Case Officer: Mr S Davis
Telephone: 01903 737874
Email: Simon.Davis@arun.gov.uk

Application No: FP/137/21/HH
Site Address: 10 The Grove Felpham PO22 7EX
Description of works: Creation of new first floor and erection of single storey front porch extension following the demolition of existing garage and rear sun room

Thank you for your internet representation made on 23rd July 2021 which has been recorded as an objection with the comments as follows:

Proposed Elevations

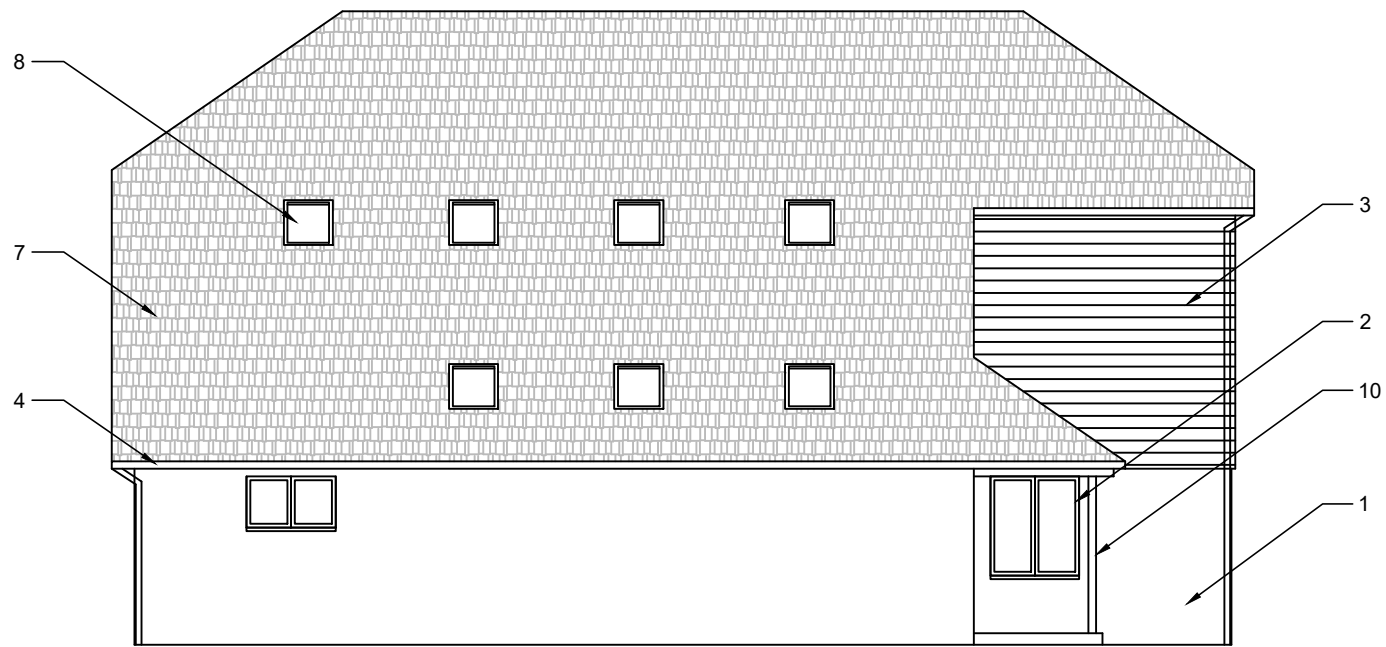
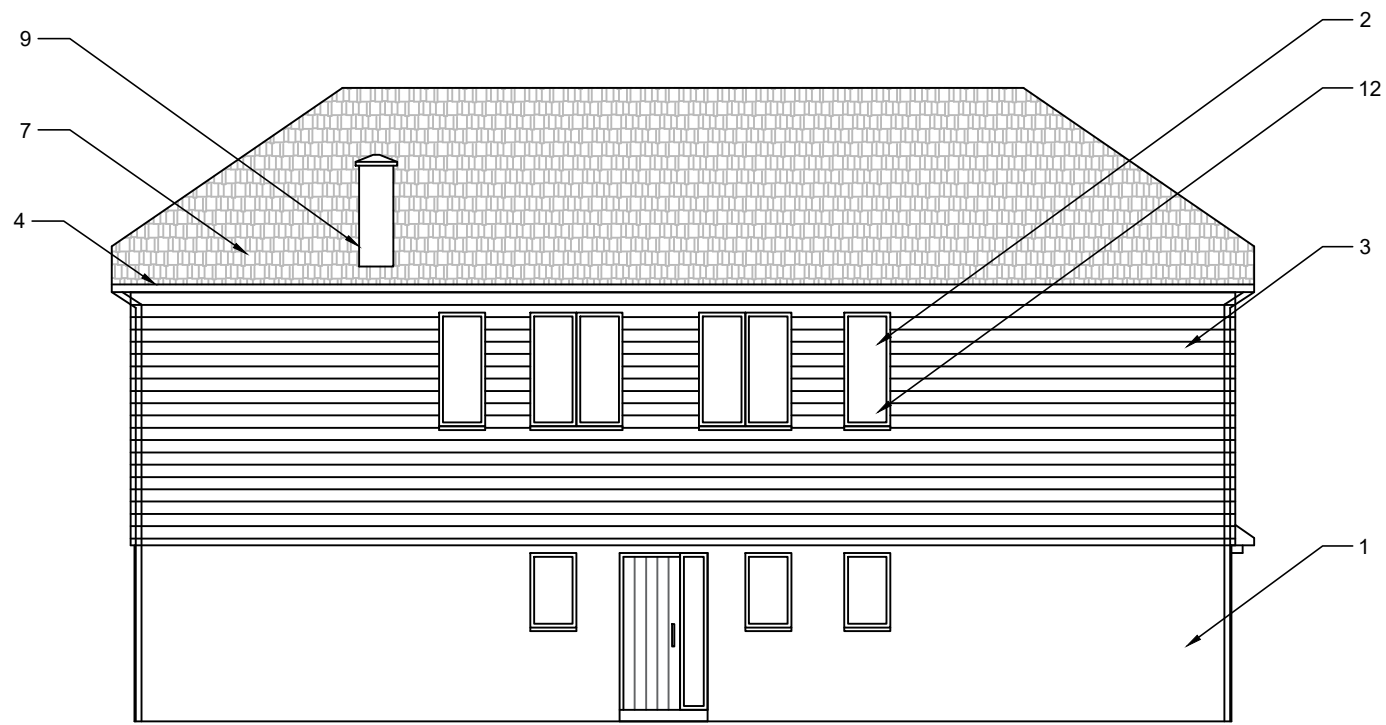
-The current plans show a wall more than twice as high as it is currently, right on the boundary edge with a bank of south facing windows overlooking my property. This is of concern because it overlooks my garden, kitchen and bathroom. The building is so close that it is inevitable that it will significantly reduce the light into my property.

-I note on the drawing (that the developer has shared with me) that the windows will have opaque glazing. However, as they are south facing, I would fully expect them to open the windows and in time even change them to normal glass. In addition, the length of the building means that some of the windows will have an unobstructed view over my garden, meaning there would be no privacy at all. I must stress that I have lived at the property for 33 years and enjoyed a totally secluded garden so this is of significant concern and worry to me. I would invite the planning officer, Ms Kaur Singh to come and see the situation for herself.

- Develop the building and keep it to the existing height
- Reduce the number of south facing windows, particularly those looking directly into and over my garden

-Reduce the length of the first-floor extension to align with the neighbouring properties
